UPDATE OF LIST OF PLANNING APPLICATIONS TO BE DECIDED BY

Planning Application 2026/90484

Change of use from dwelling to C2 for 4 children, erection of first floor extension and front porch, internal and external alterations

143, Church Lane, Gomersal, Cleckheaton, BD19 4QN

Existing Ground Floor General Arrangement Plan 1:50

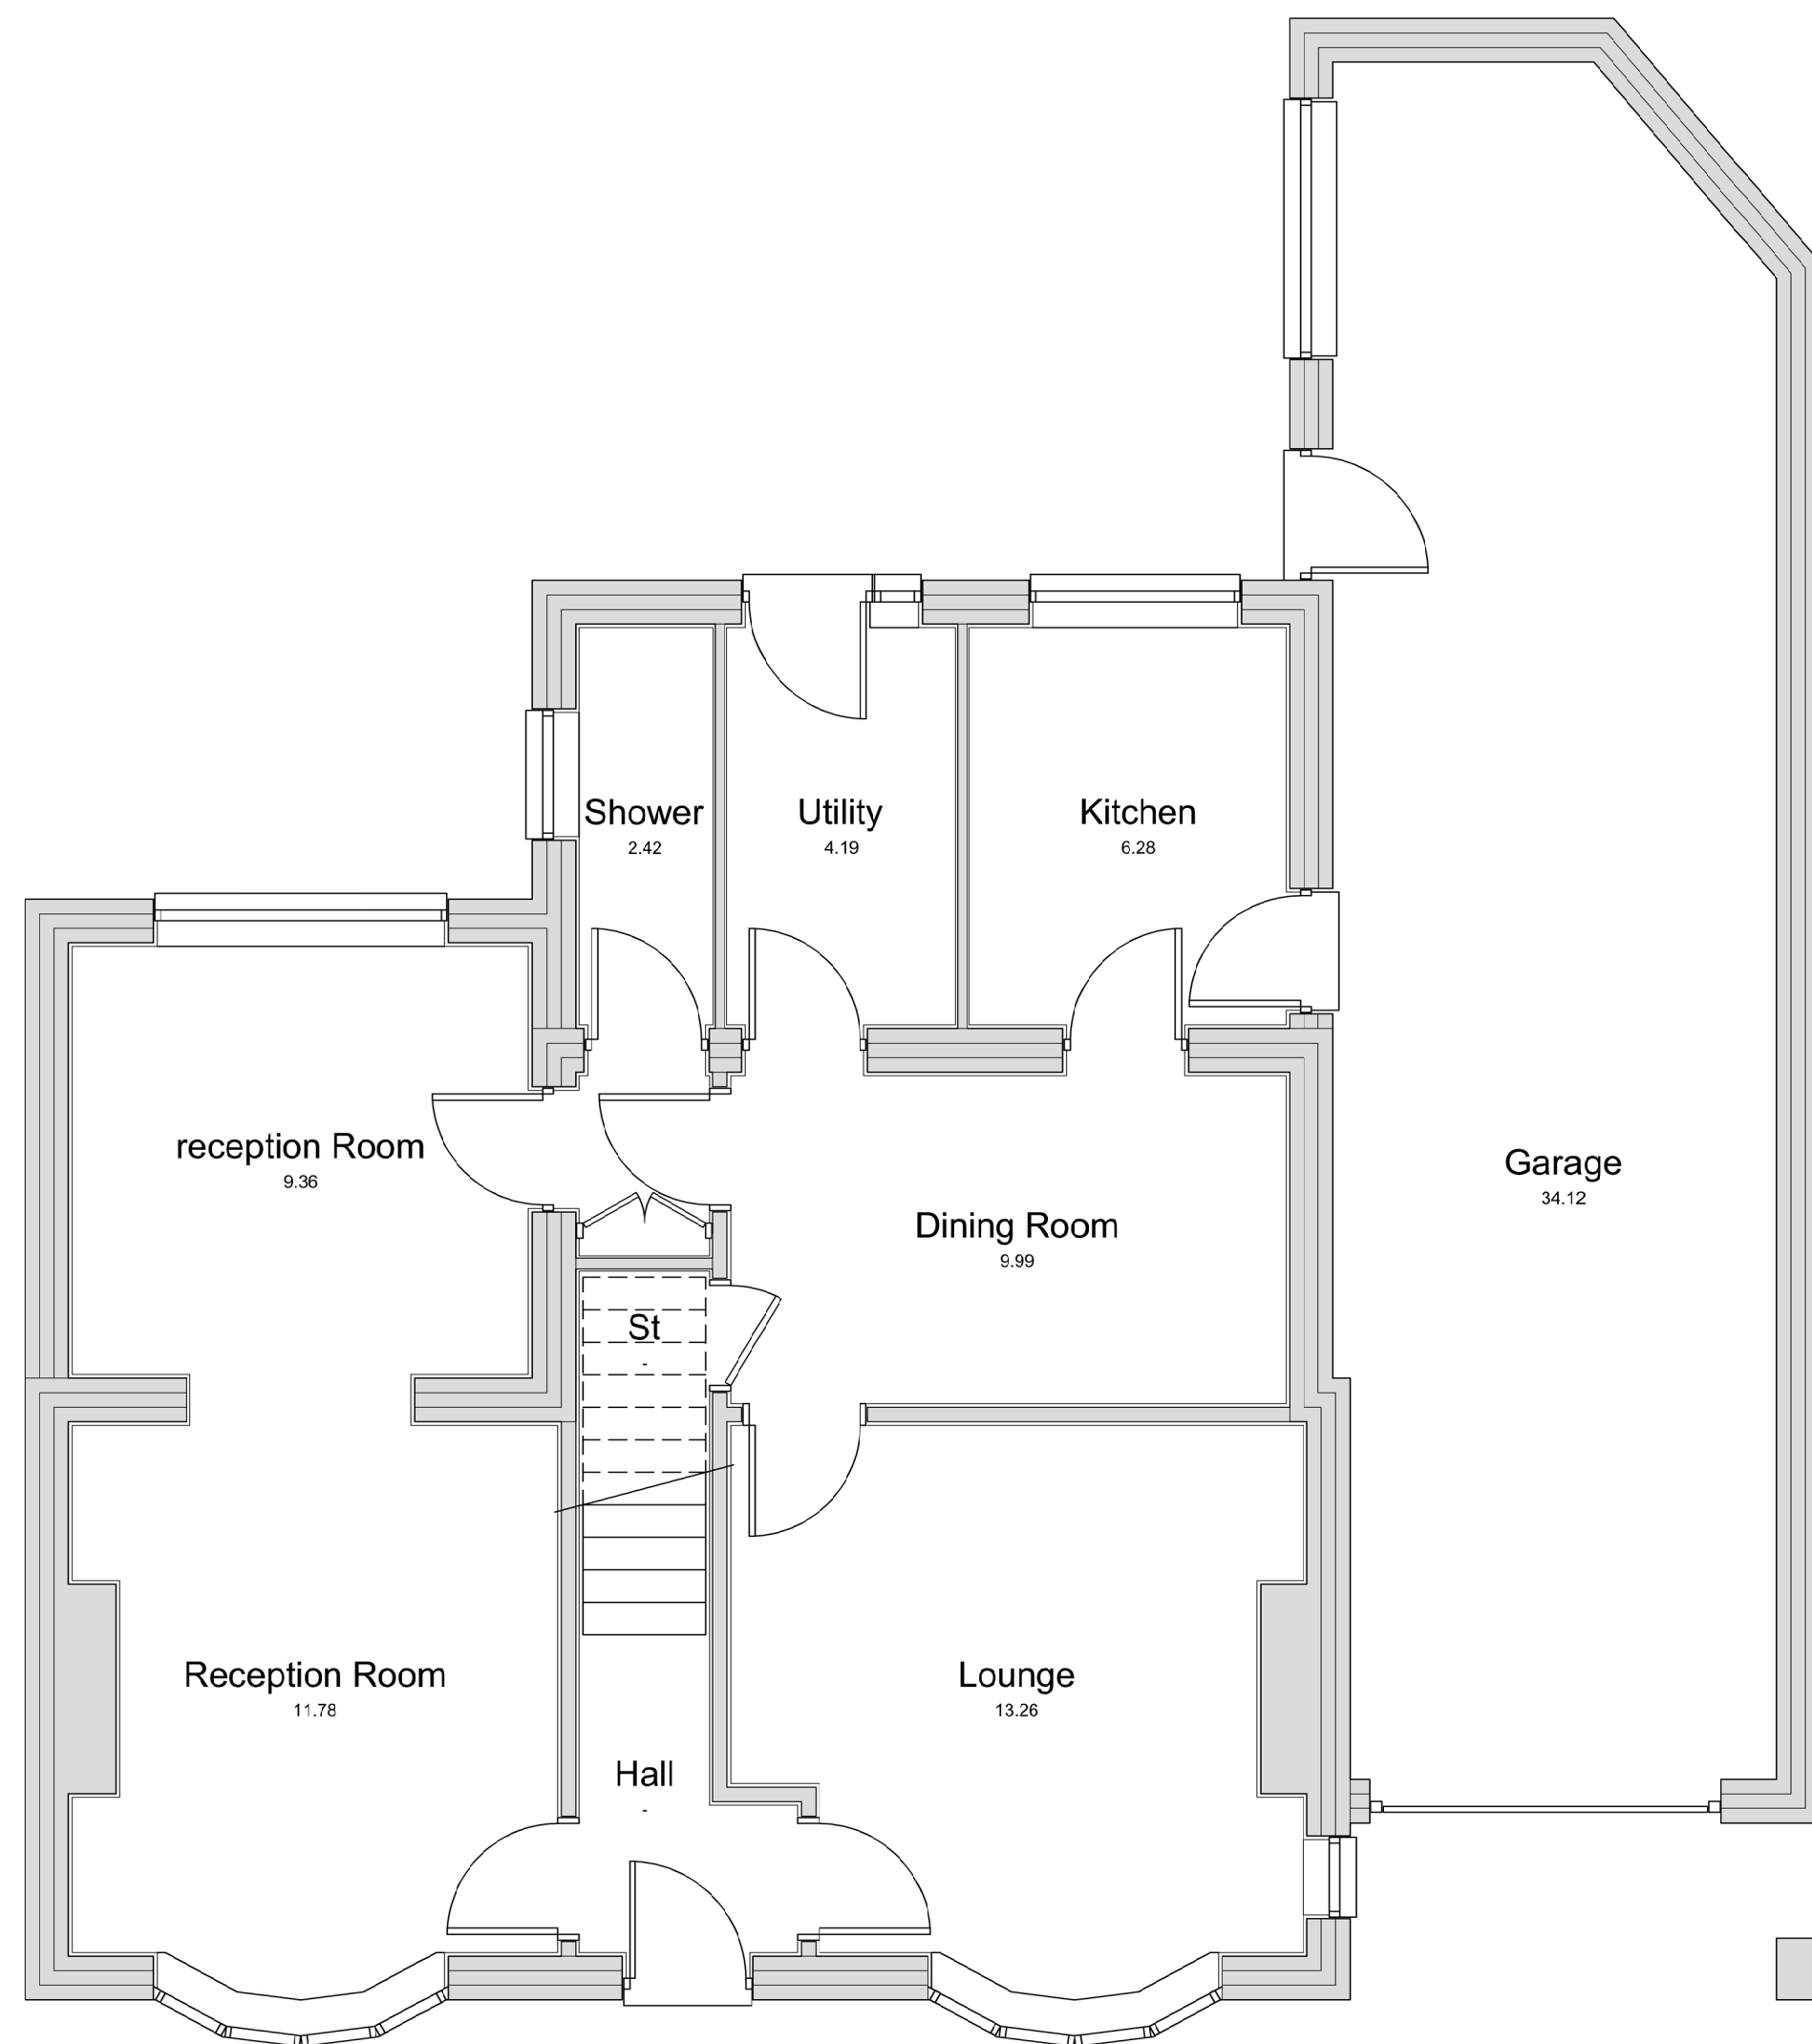
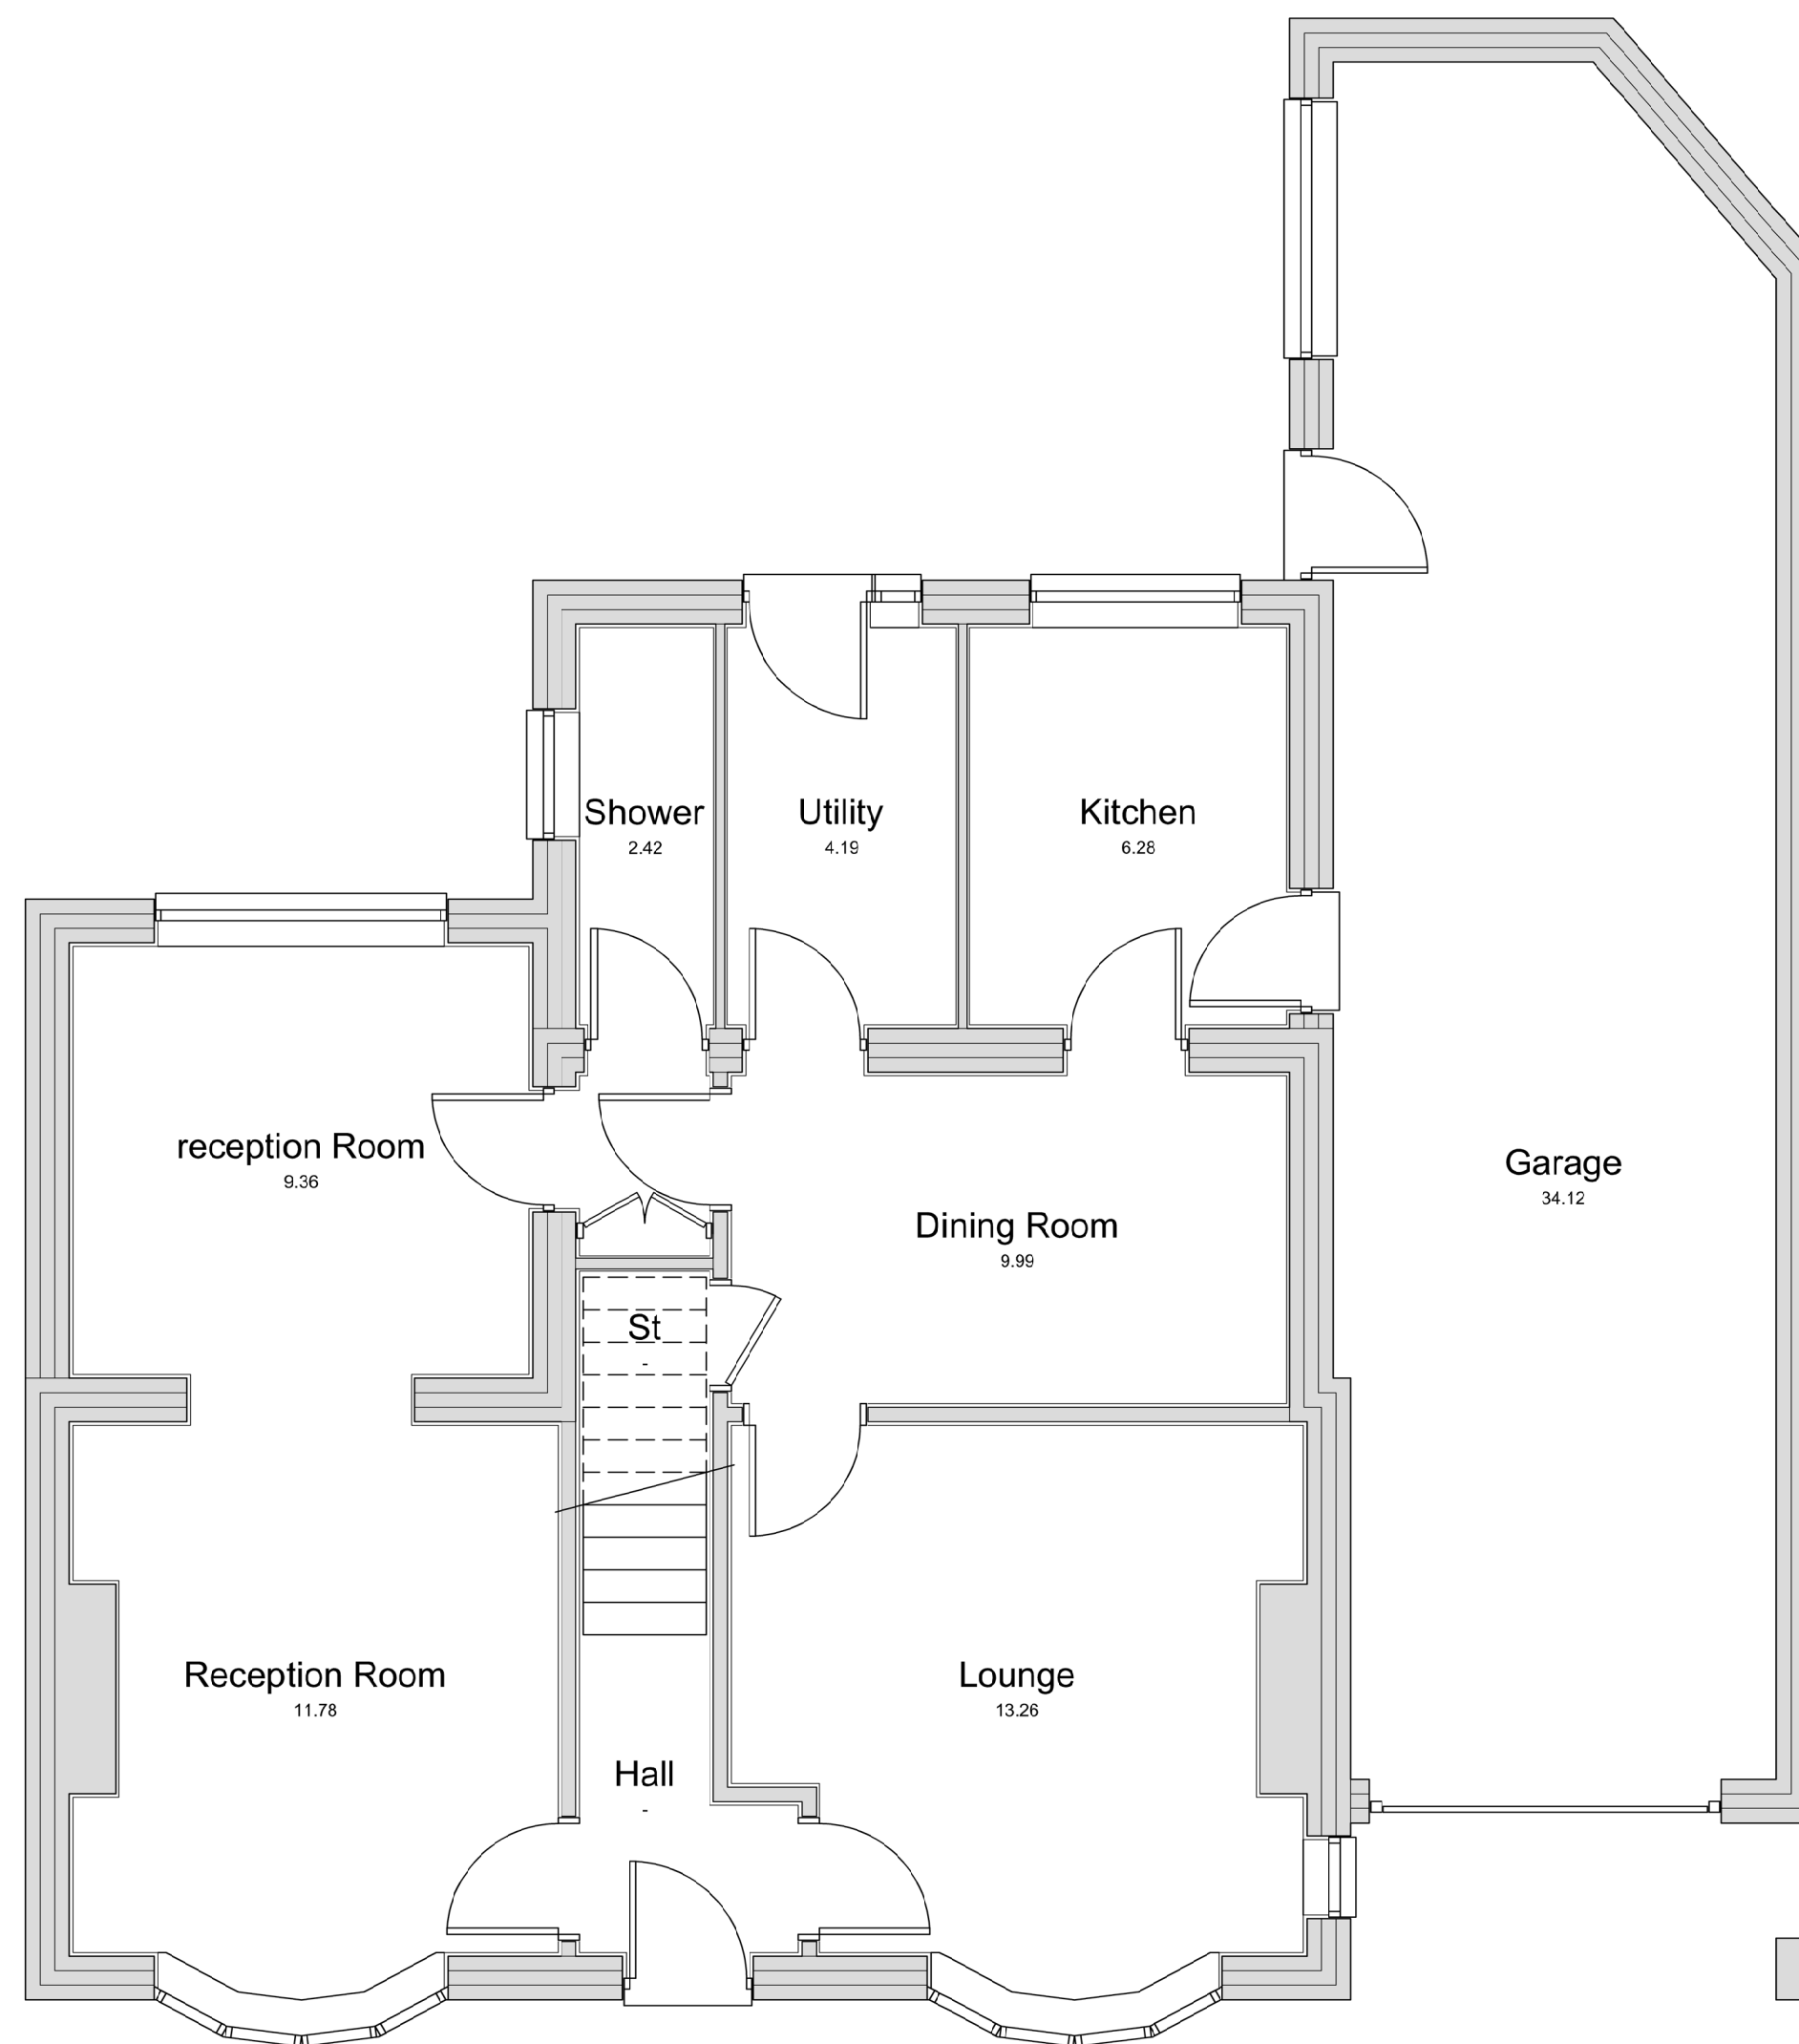
A correct existing first-floor plan and verified measured survey

- There is **no correct existing first-floor plan** on the application file; the purported existing floor-plan sheet appears to reproduce the ground floor twice.
- **No verified original-building plan or cumulative enlargement calculation** is published, yet the officer concludes that the Green Belt test is satisfied.
- **Only two parking spaces are shown and acknowledged**, but their **dimensions, lawful site position and access over an authorised crossing** have not been demonstrated.
- The officer report **does not adequately resolve the specialist police safeguarding objection** or the **factual conflicts in the applicant's late supporting documents**.
- Approval would therefore rest on **unverified plans, boundaries, access arrangements and operational assumptions**.

What is wrong or missing: The application contains **no correct existing first-floor plan**. The floor-plan sheet appears to show the ground floor twice, and **no verified drawing identifies the original dwelling or all later additions**. The report publishes **no cumulative footprint, floorspace or volume calculation**. It also **compares the latest additions with the already extended 'existing building' before asserting compliance with the original-building test**.

1. Where is the **correct existing first-floor plan**, and why does the existing floor-plan sheet appear to reproduce the ground floor twice?
2. Where is the **verified plan identifying the original building and every subsequent extension**?

Officer Response: The Local Planning Authority has adequate information upon which to assess the proposal.
